SUBJECT: Engineering Review Comment  
Mountain View Electric Association Inc. (MVEA)

**Project Name: Private Ice Rink – Dimensional Relief**

**Project Number: BOA236**

**Description:** Proposed development of an ice rink on approximately 17 acres located at 16735 Happy Landing Dr. in Township 11S, Range 66W, Section 20.

SITE PLAN

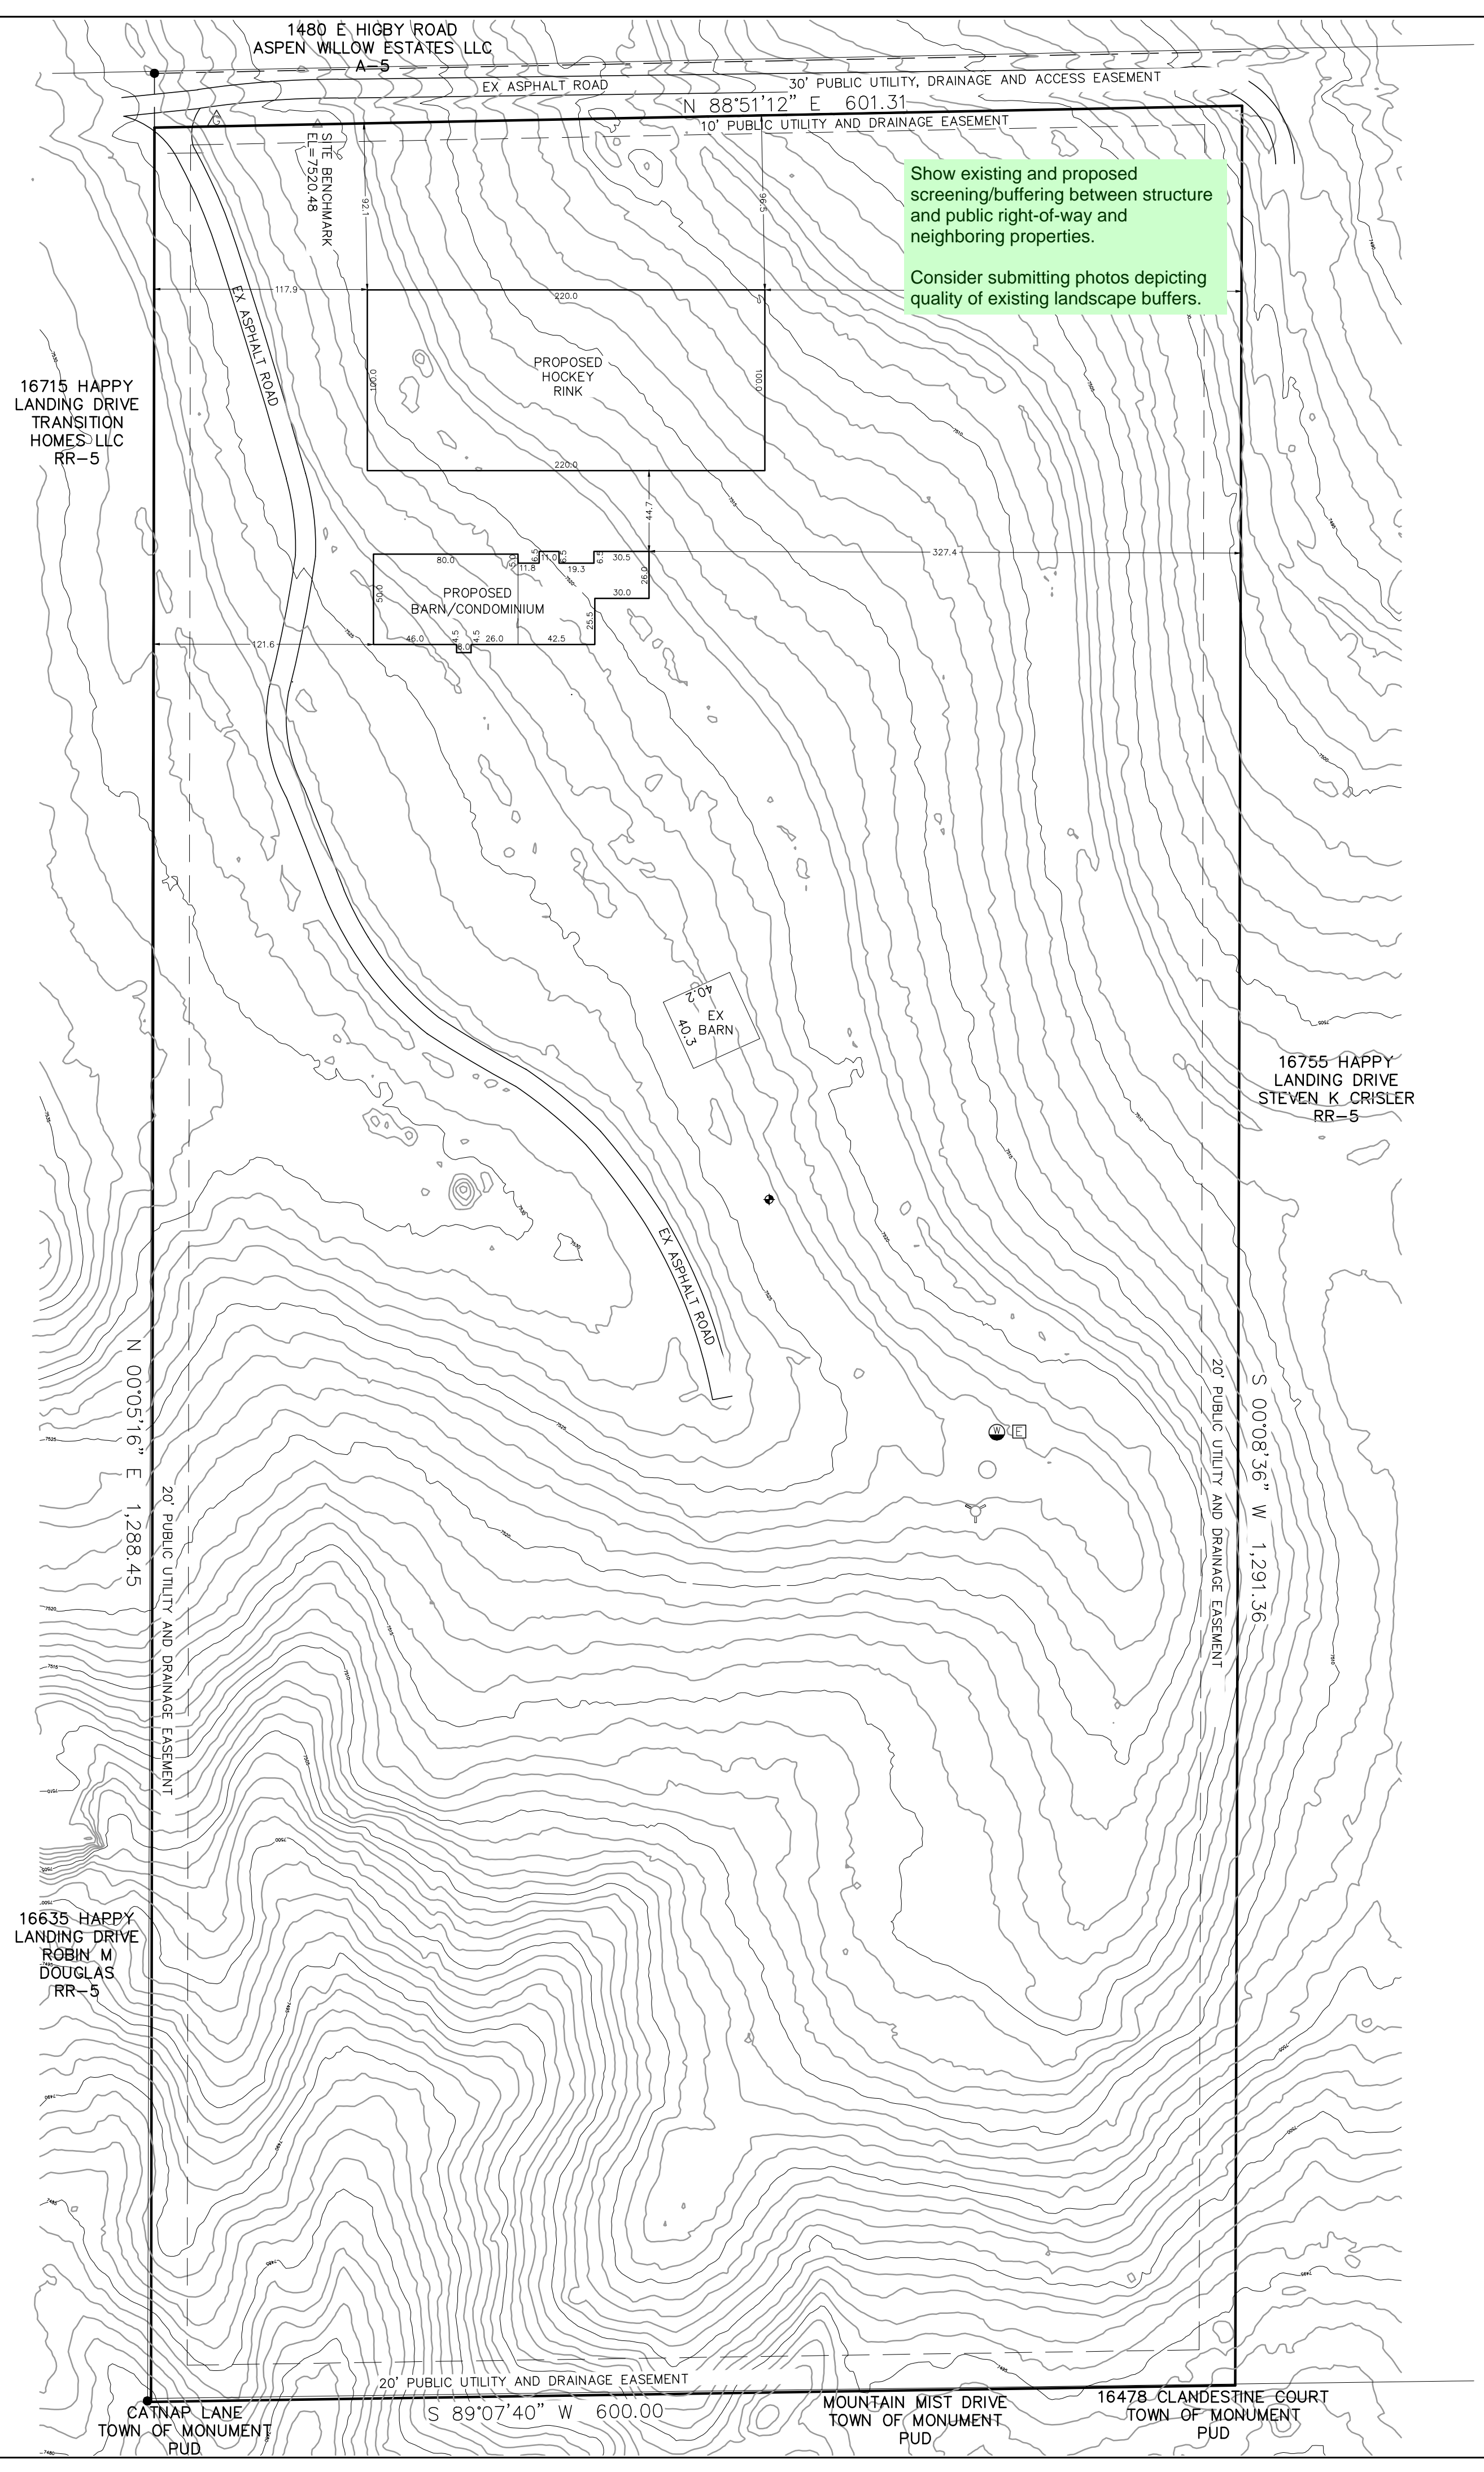
MVEA has existing facilities and a recorded easement on Lot 1, reception number 217103169. Locates are needed for the existing facilities and the easement must be shown on the site plan drawing. No permanent structures are allowed within the easement.
